1. Representation have been received from Stantec (Bicester Gateway Phase 1B Residential TN005 dated 28th January 2019 [sic]) and Motion (Catalyst Bicester Transport Review TN1 dated 17th October 2019), representatives of Bicester Gateway Ltd (Bloombridge) and Value Retail Ltd respectively. This note responds to matters raised therein.

JOB TITLE		CLIENT	
CATALYST BICESTER		ALBION LAND	
DRAWING TITLE			
WENDLEBURY ROAD FOOT/CYCLEPATH ENHANCEMENT WITH HEALTH AND RACQUETS CLUB			
SCALE	DRAWN BY	DATE	DRAWING No
1: 500@A1	RJM	03/05/19	19539-12-01
			REVISION
			B

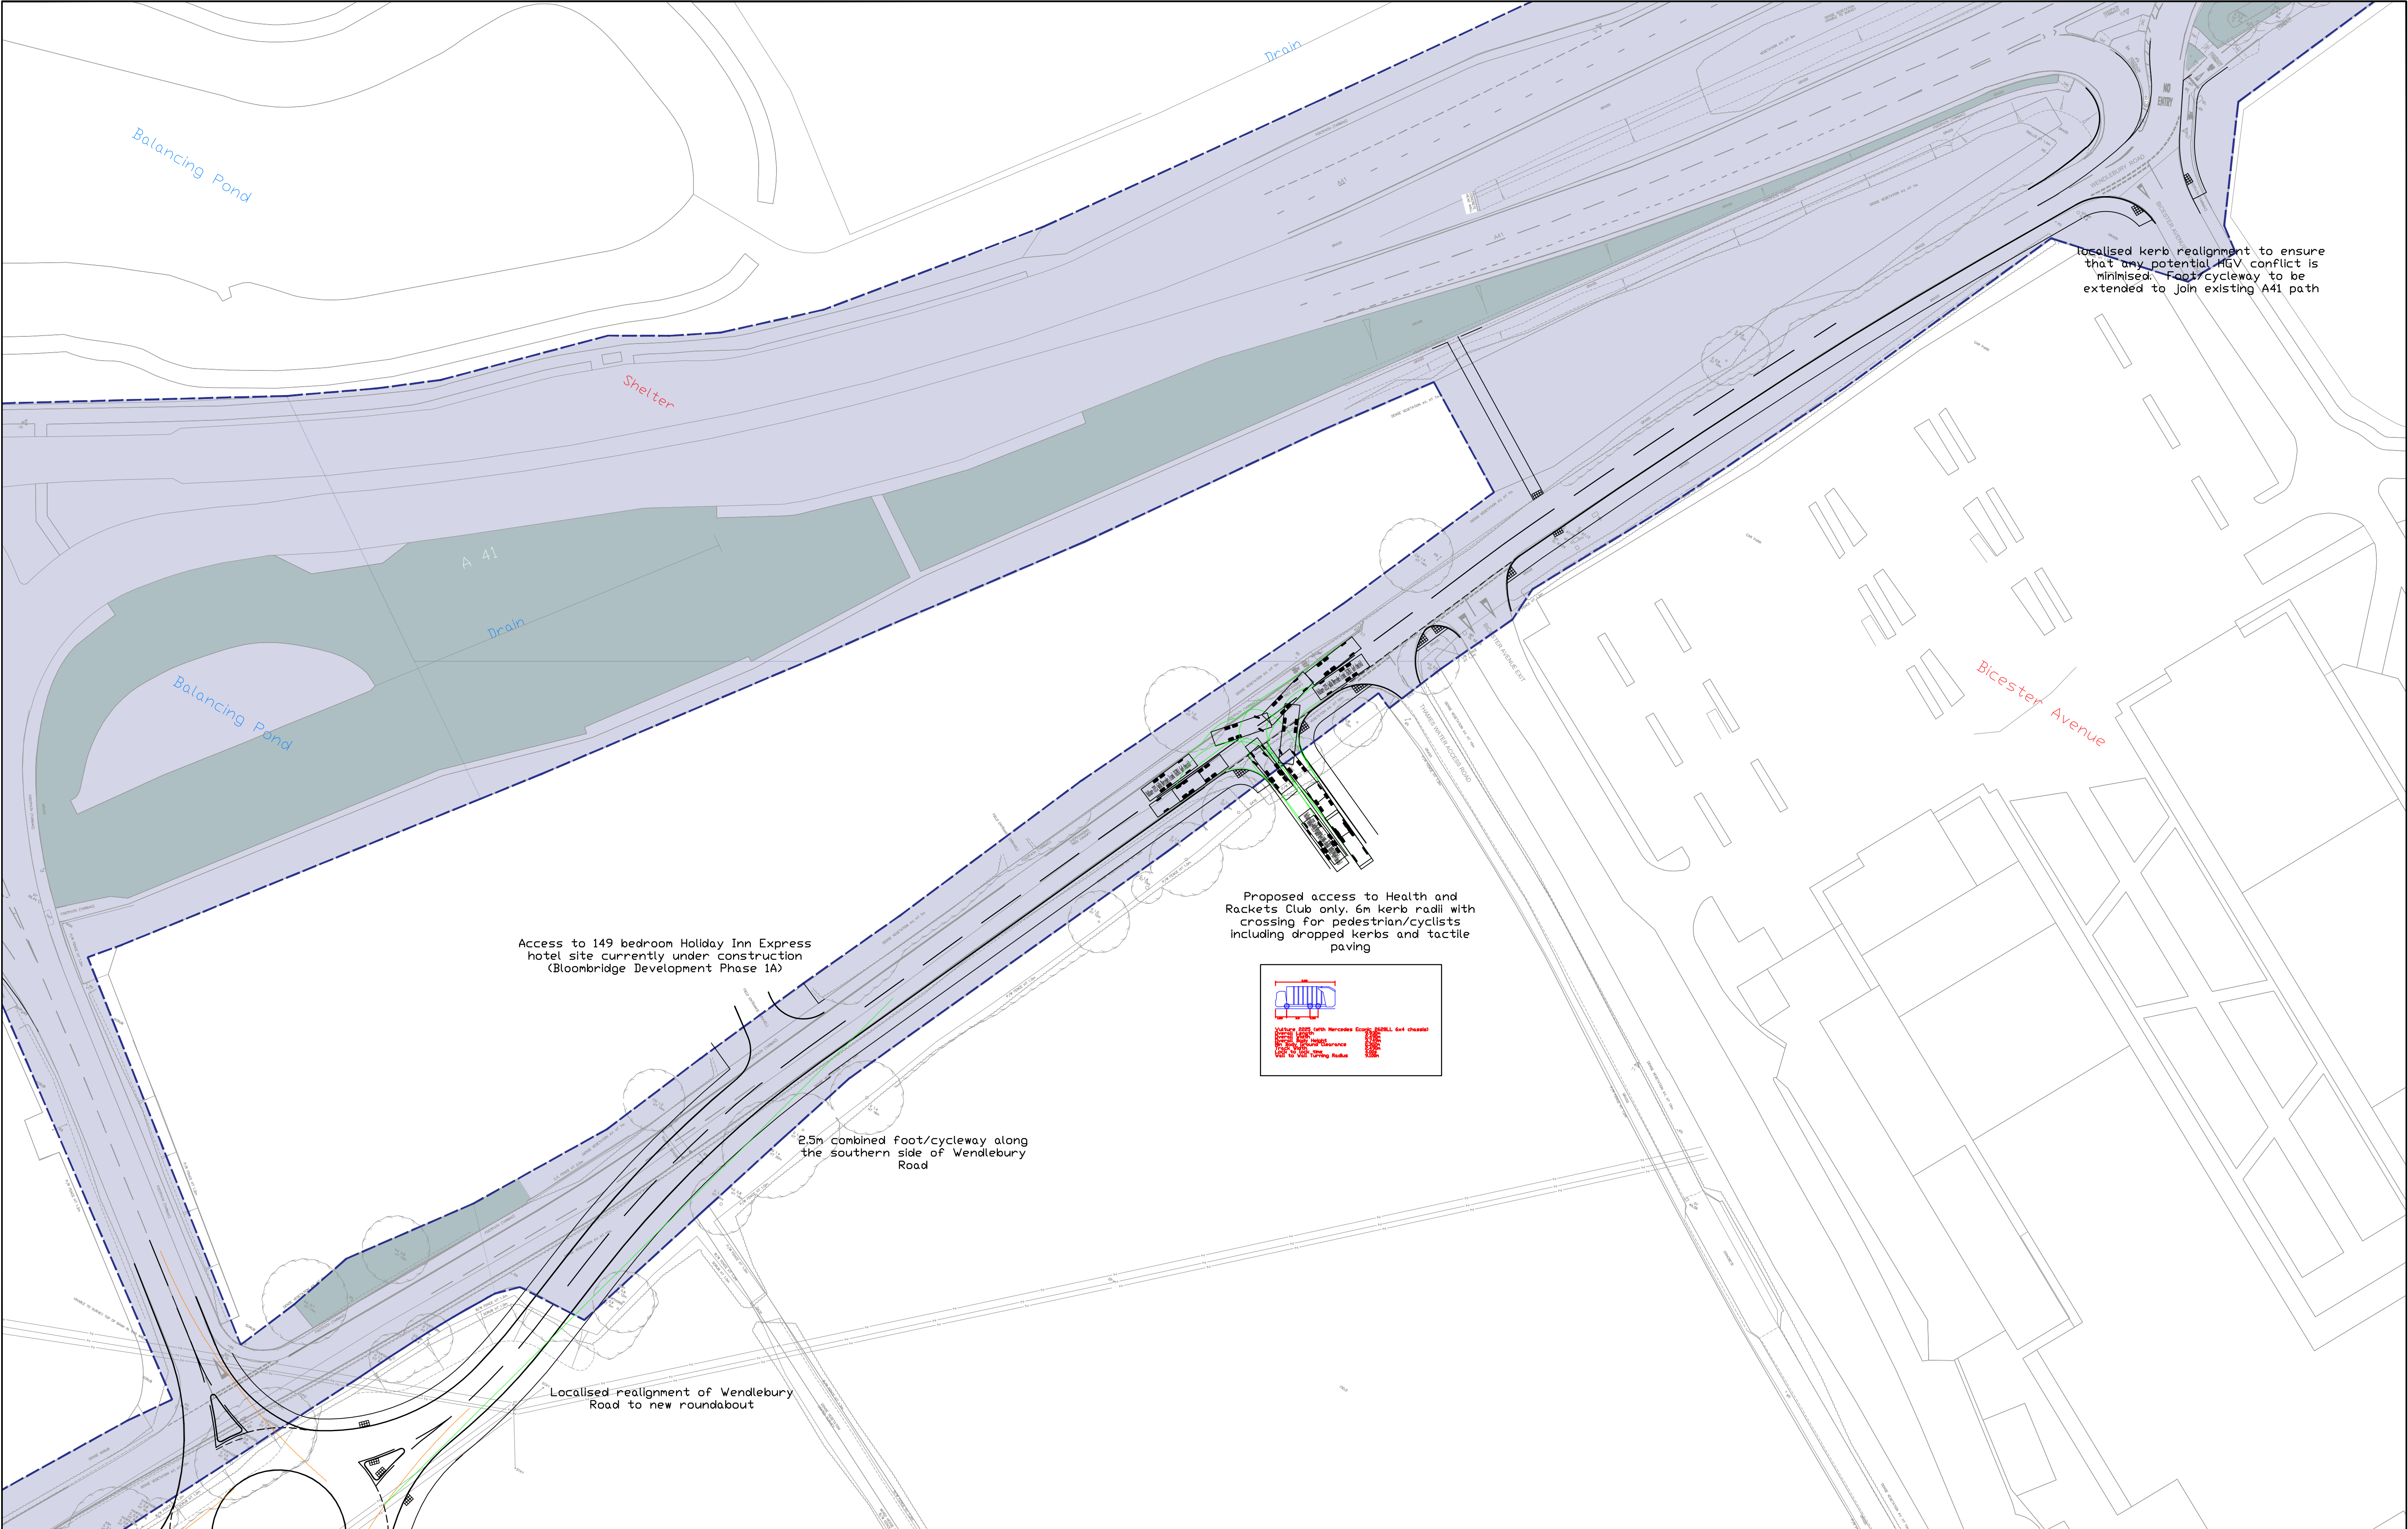
10. A 3m combined foot/cycle way will be constructed from the site access roundabout to the toucan crossing at A41/Pioneer Way providing a direct link into the Kingsmere housing and linking up with the cycle path improvements secured by the Bicester 4 consent for onwards connections to the north. Any narrowings to address localised constraints will be short and maintain at least 2.5m in full accordance with best practice guidance. At present it is anticipated that such as narrowing will only be required near the entrance to Bicester Avenue

for a distance of <10m. Where appropriate cycle priority measures will be provided at accesses and local junctions.

11. With respect to cyclists on Wendlebury Road to the south of the site access roundabout towards Wendlebury, this road is part of the National Cycle Network. Whilst it is understood that the Bloombridge Phase 1B development is likely to load all its vehicular traffic onto this link, the Albion Land employment will be accessed solely from the site access roundabout which will link across directly to the A41. As such it is likely that the only additional traffic using this road will be local traffic e.g. residents from Wendlebury and Chesterton who want to use the gym or work on the site. Ideally the existing character of the road south of the site access would be maintained in so far as is possible. Whilst the independent Road Safety Audit recommended stopping the off-road cycle provision at the site access roundabout, OCC has reviewed this and requested that it be extended a short distance to the south before rejoining the carriageway. Ultimately Bloombridge can link their pedestrian and cycle accesses to these paths when their accesses are determined in any future planning application. For northbound cyclists it is proposed that a path along the current Wendlebury Road road alignment would be retained to link up to a splitter island on the Vendee Link Road arm of the site access roundabout and this would connect to the existing foot/cycle path. This would be facilitated by the localised re-alignment of Wendlebury Road to the south of the site access.

JOB TITLE CATALYST BICESTER		CLIENT ALBION LAND	
DRAWING TITLE WENDLEBURY ROAD SITE ACCESS ROUNDABOUT			
SCALE 1: 500@A1	DRAWN BY RJM	DATE 03/05/19	DRAWING No 19539-12-02
REVISION B

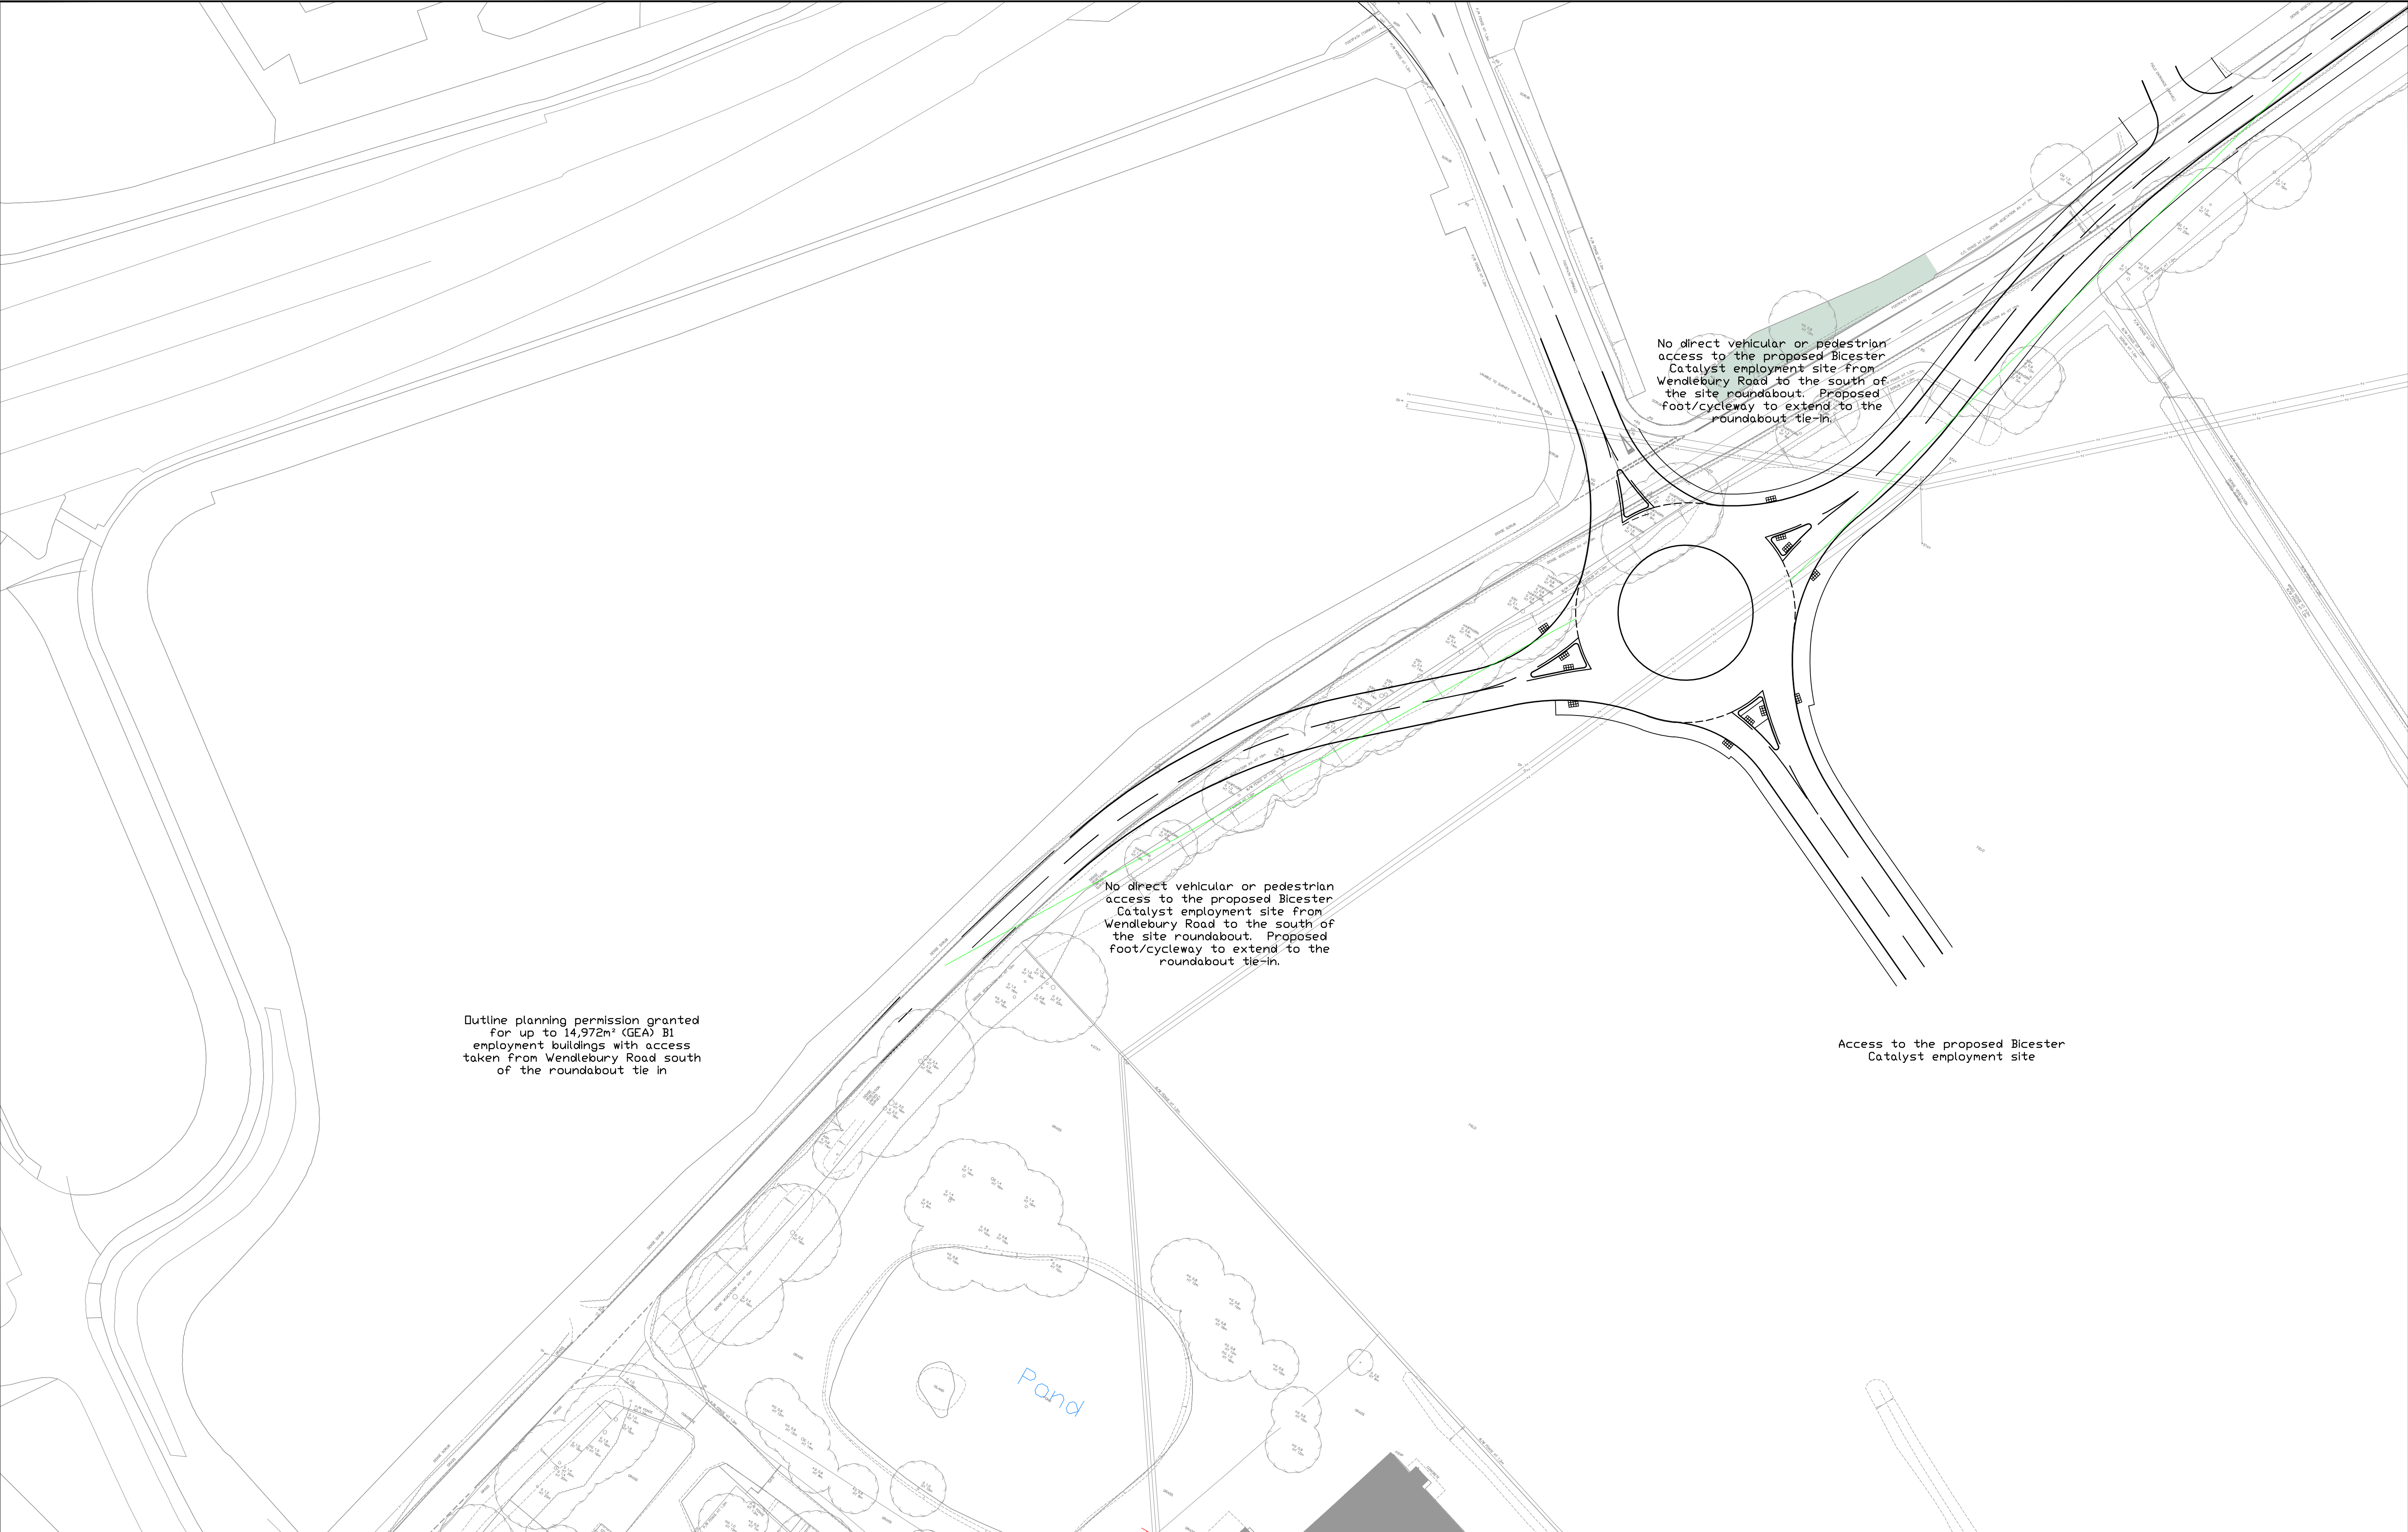
18. The proposed development does however offer a significant enhancement in terms of the junction of the Vendee Link Road and Wendlebury Road. This will be upgraded to a roundabout with entry path curvature and visibility in accordance with standards and pedestrian and cycle facilities to ensure that the requirements of all road users are met. This will be a significant benefit to all road users, including those accessing the Bloombridge site, given the limited capacity of the existing layout. It also avoids implementation of the mini-roundabout scheme previously proposed by Bloombridge which (as indicatively proposed) is poorly suited to commercial traffic, does not meet the standards set out in CD116 including departures on minimum visibility requirements and made no provision for pedestrians or cyclists. The proposed Phase 2 roundabout not only enables the Albion Land development but it is unclear how the Bloombridge phase 1b site could come forward without it.
